AB/42/26/L

Address: 18 Bond Street Arundel BN18 9BL

Proposal: Listed building consent for repair works to timber windows, masonry, dormer, leadwork and outbuilding chimney, with minor internal alterations.

Elevations -
Proposed

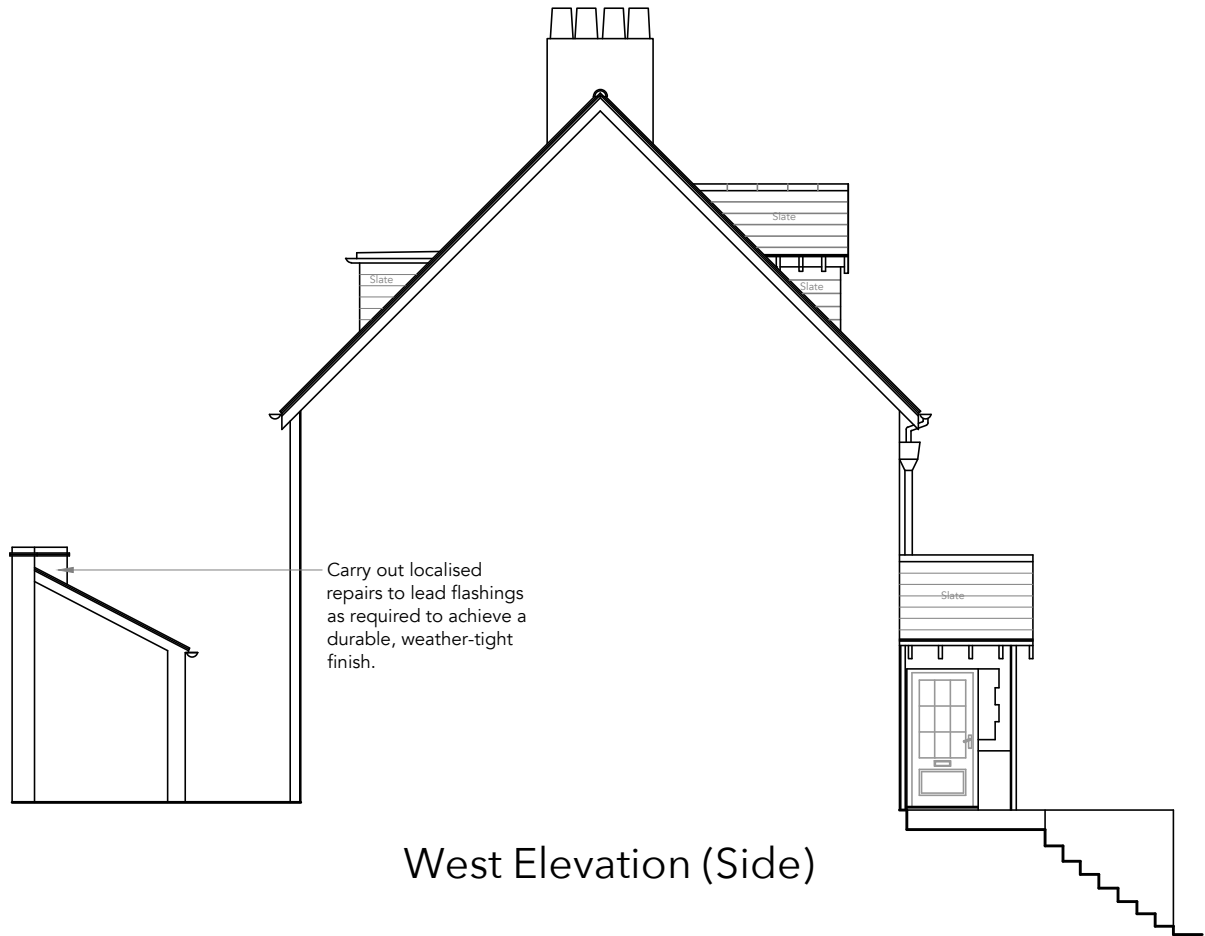
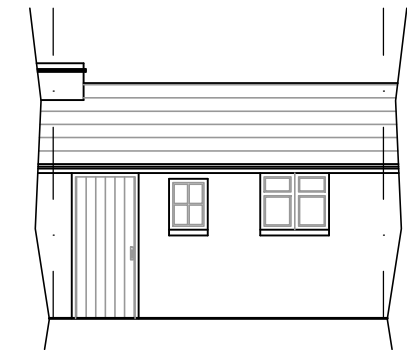
The majority of the works are works of repair which is positive. However, it is not clear why the timber windows can't be repaired with timber, as opposed to resin. It is also not fully clear what the methodology or materials will be used for the repairs to the Pulborough Stone. Likewise, it is not clear what the repointing would look like when completed, and a sample panel would assist this. It is also not clear what work of repair will be undertaken to the chimney, nor the method for removing the non-breathable paint - can this be clarified.
